# CITY OF ALBUQUERQUE

**Re: Atrisco Apartments, 1720 Atrisco Dr NW, Traffic Circulation Layout  
Architect's Stamp dated 10-22-12 (H11-D068)**

Based upon the information provided in your submittal received 10-25-12, the above referenced plan cannot be approved for Building Permit until the following comments are addressed:

1 TCL - Traffic Circulation Layout Plan
1" = 20'-0"

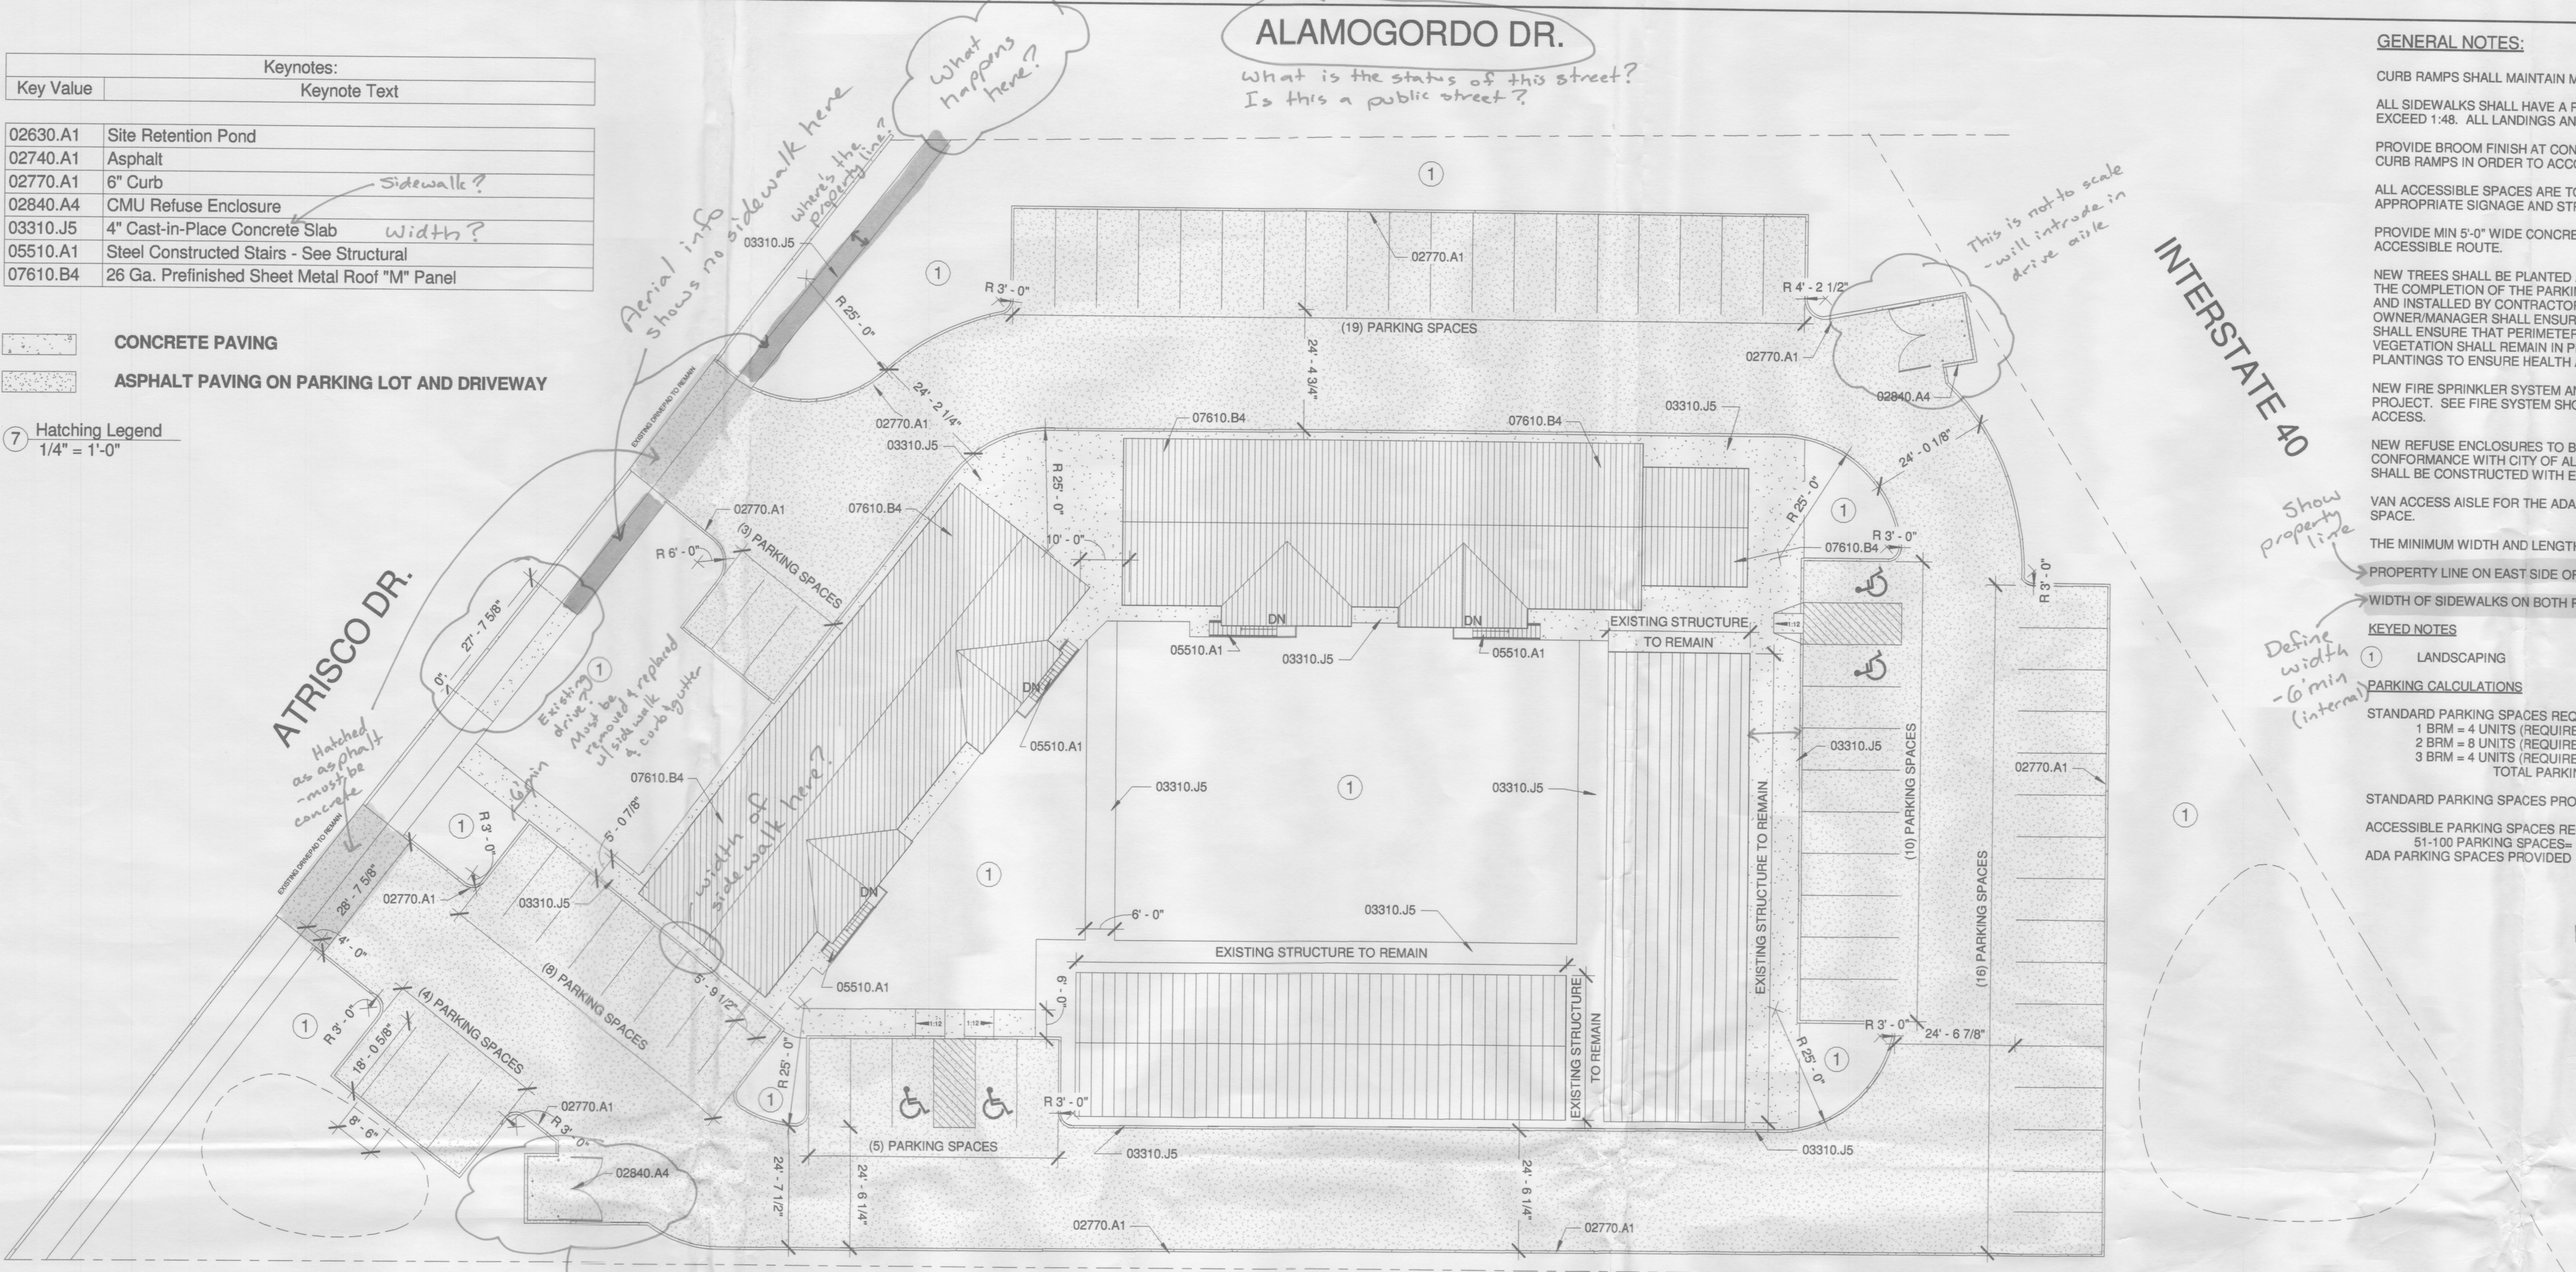
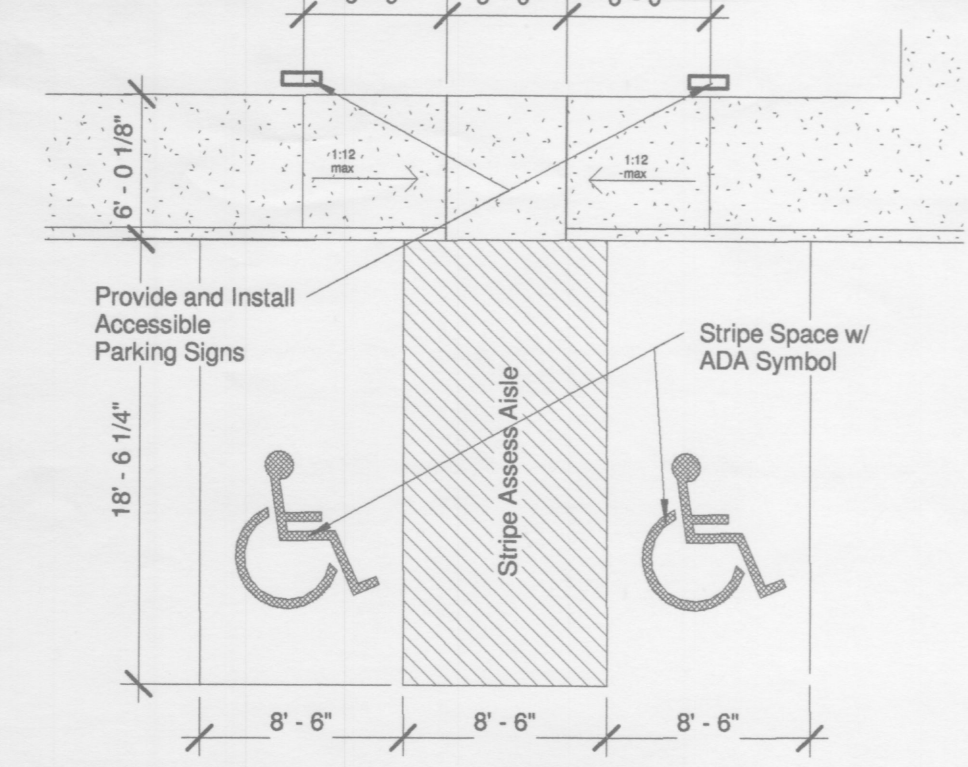
1. Clearly show existing versus proposed conditions. For example: indicate existing sidewalk to remain, existing driveways to remain, existing driveway to be removed and replaced with sidewalk/curb & gutter, existing asphalt and proposed asphalt.

4. List radii for all curves shown; for passenger vehicles, the minimum end island radius is 15 feet.
5. Please list the width and length for all parking spaces.

6. Define width of all sidewalks, proposed and existing.
7. List the width of the proposed curb cuts.
8. The TCL includes two ADA ramp details (numbers 2 and 6) but they are not referenced on TCL site plan. Please clarify the proposed locations.

9. The ADA handicap parking spaces must be clearly identified on the TCL.
10. The striped access aisle for the ADA accessible parking does not count as a parking stall. Please amend the notes and parking calculations accordingly.

11. There is a discrepancy between the number of parking spaces provided on the TCL layout and the proposed parking listed in the general notes.
12. List the width of the existing driveway.

14. Clarify existing conditions along Alamogordo Drive. The emails included with this submittal are unclear; is Alamogordo Drive being vacated?
15. Clearly show the property line along all frontages.
16. The trash enclosures are not drawn to scale in the TCL layout. The northern trash enclosure appears to reduce the drive aisle to approximately 19-20 feet when drawn to scale. Two-directional traffic requires a minimum 24-foot wide aisle width. Please provide a layout to scale and provide drive aisle widths.
17. Recent GIS information indicates that this site consists of 5 lots. Show all lot lines on the plan. Will this site be replatted? If not, cross access easements are required.
